Planning Inspectorate
Arolygiaeth Gynllunio

Acceptance of Applications Checklist

The Droles Solar Farm Section 55 Acceptance of Applications Checklist

## 2.7 Statutory Ecology and Nature Conservation Features Plan

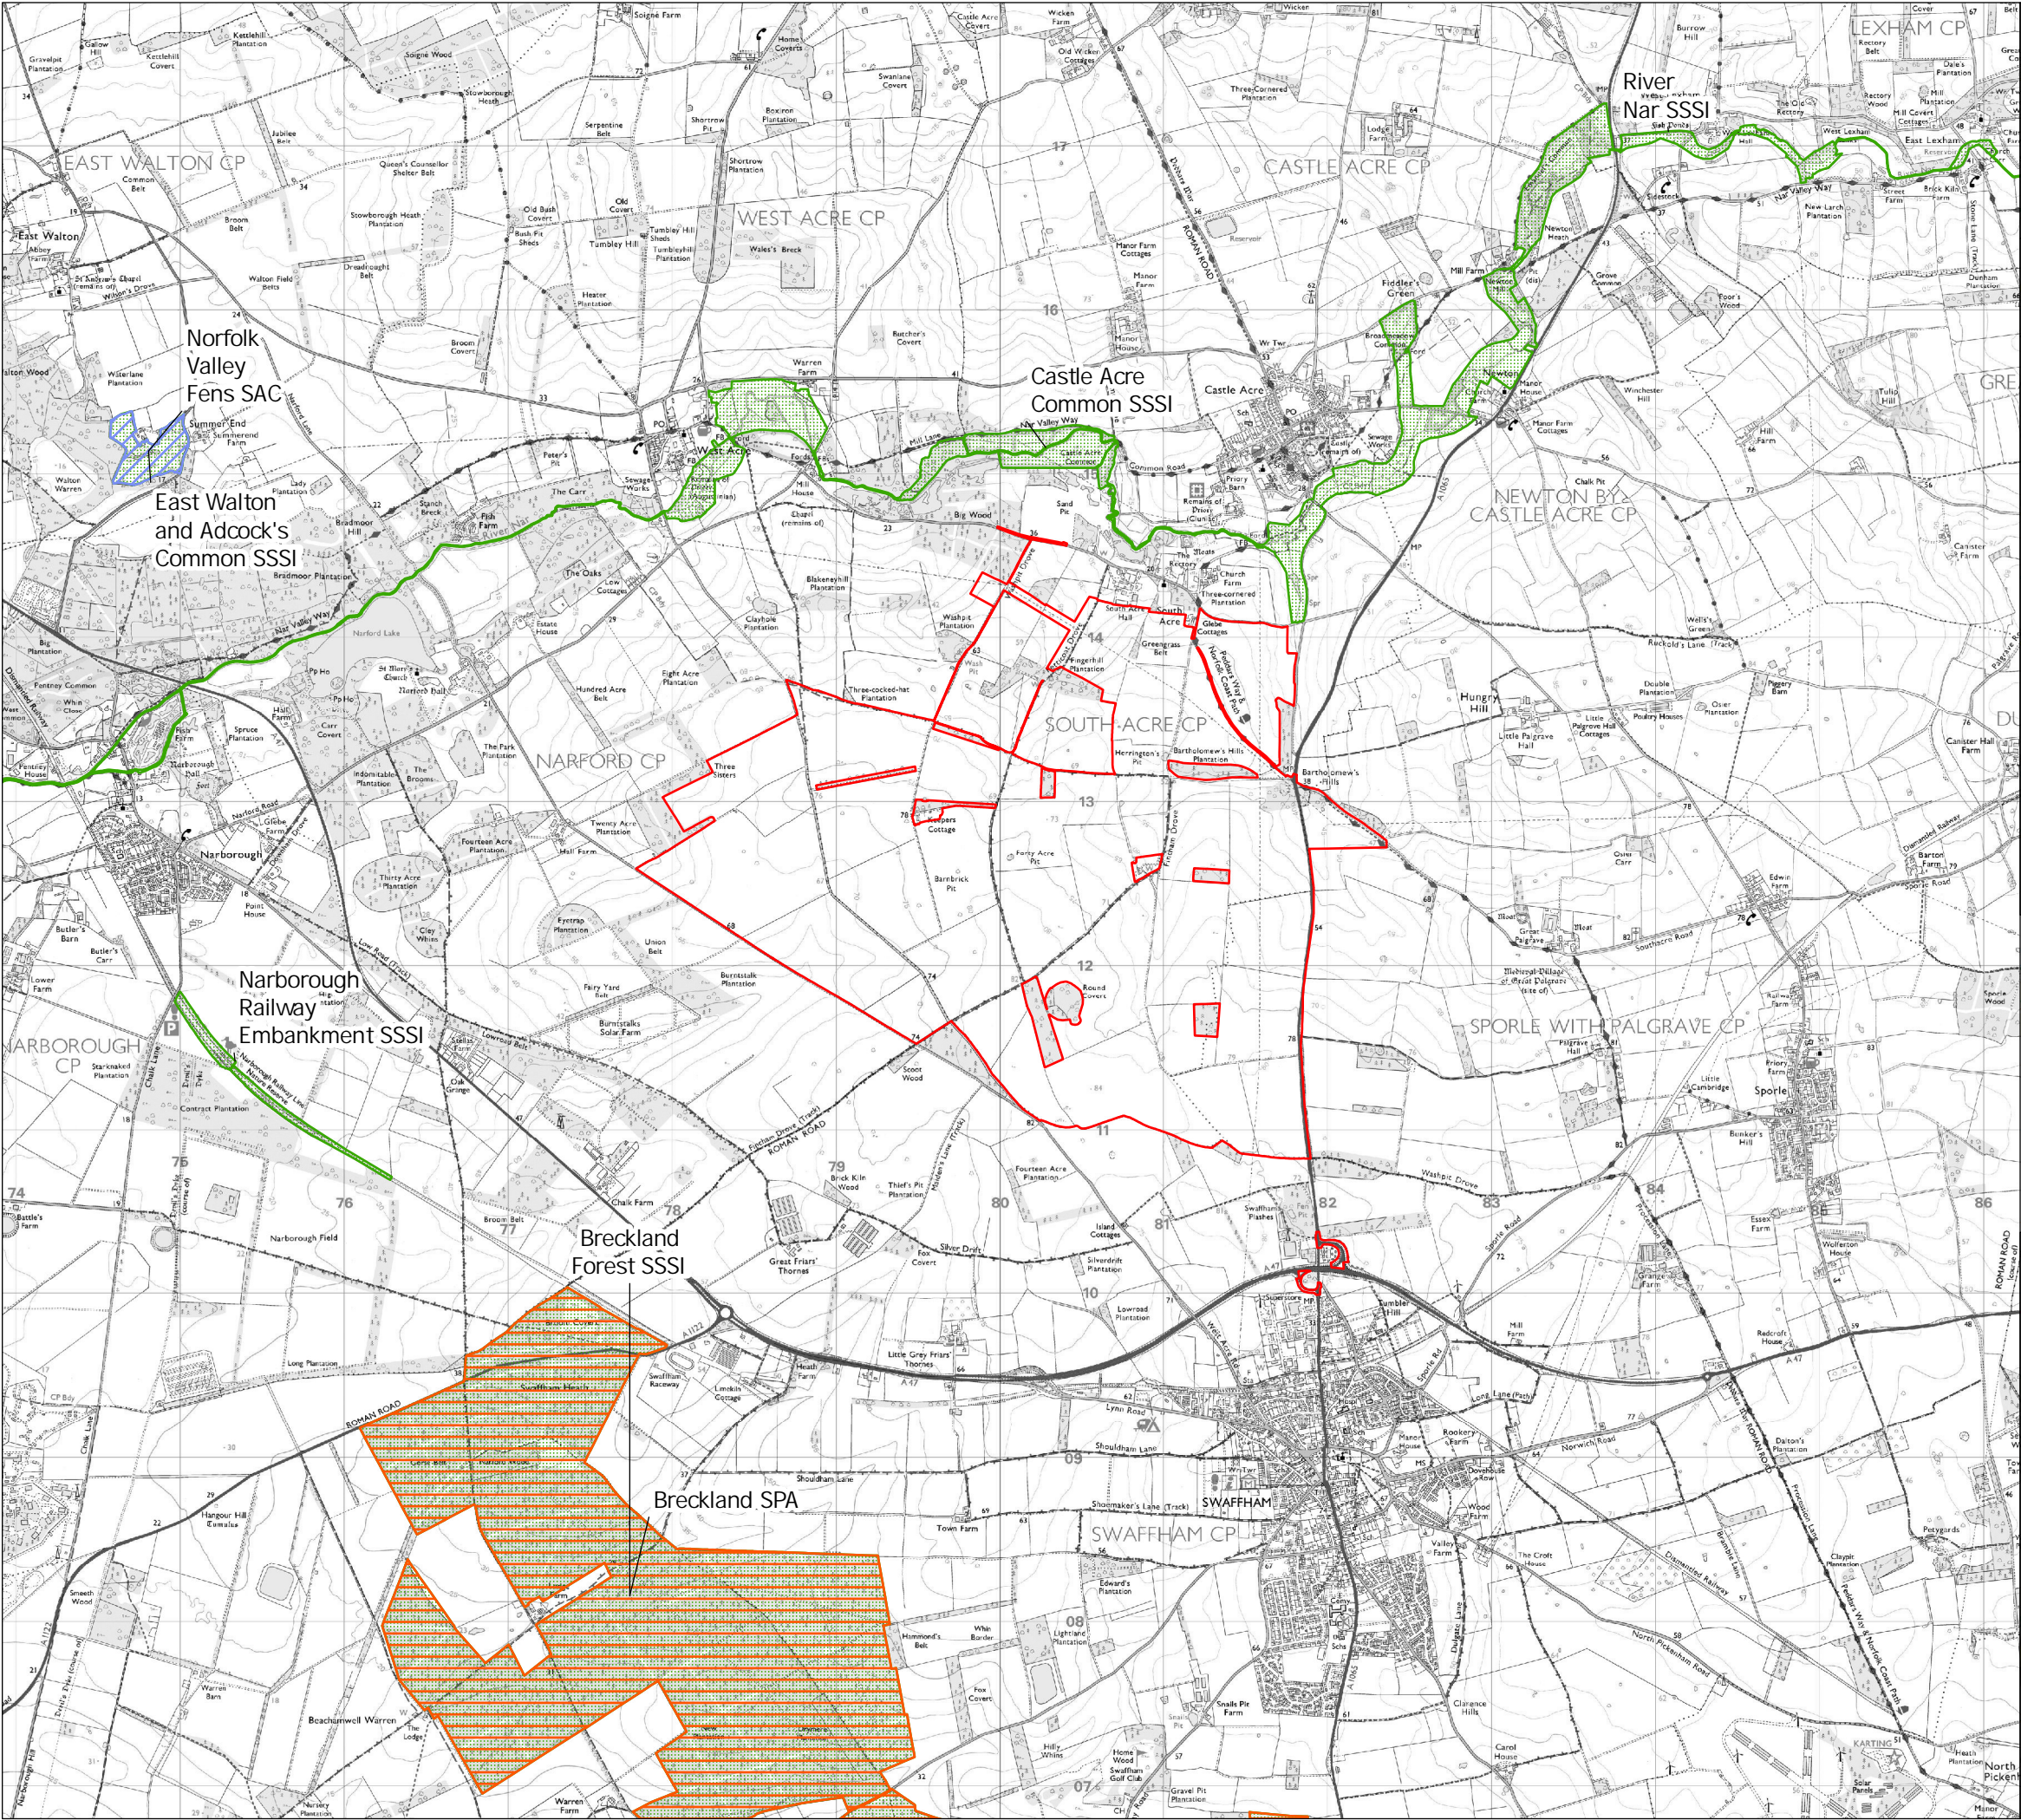
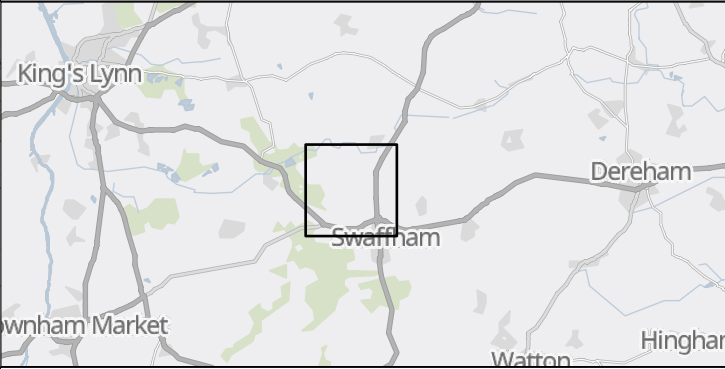
The Statutory Ecology and Nature Conservation Plan [Doc 2.7] appears to show an area which is less than the 25km distance used in the Environmental Statement’s study area from the red line boundary of the order limits of the proposed development.
